**CHARLOTTE-MECKLENBURG  
PLANNING COMMISSION**  
INTER-OFFICE COMMUNICATION

DATE: April 2, 1991  
TO: Robert Brandon, Zoning Administrator  
FROM: Martin R. Cranston, Jr., Planning Director  
SUBJECT: Administrative Approval for Petition #81-60 by C.B. Moore Heirs  
Tax Parcel #147-101-69, 149-121-02

**PROPOSED LAND USE PLAN
SELWYN FARM
MOORE ESTATE, CHARLOTTE, N.C.**

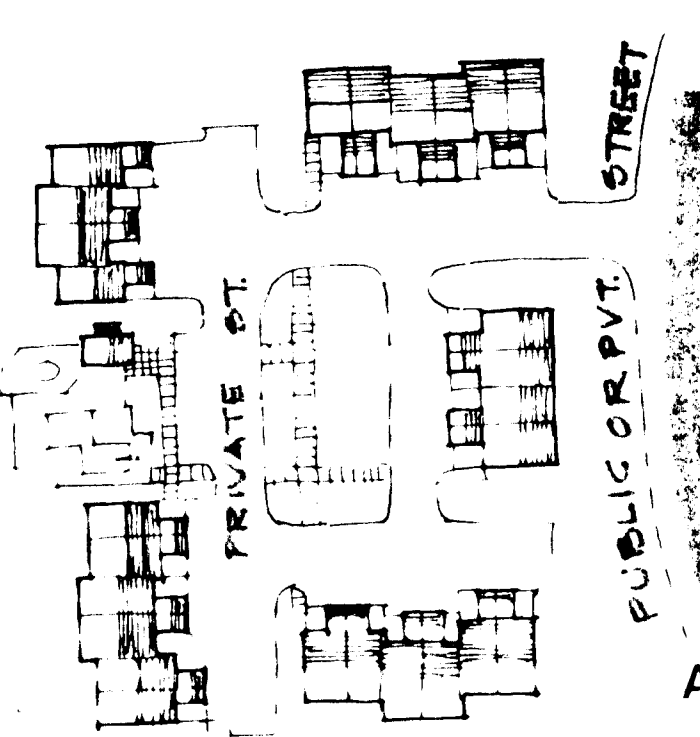
Attached is a revised plan for the above mentioned rezoning petition. The plan has been revised to change the wording on parcel #81-60 from "reserved for Broadmoor Athletic Association" to "reserved for use as a public park". Since this change is minor in nature and does not intensify the site I am administratively approving this plan. Please use this plan when evaluating requests for building permits.
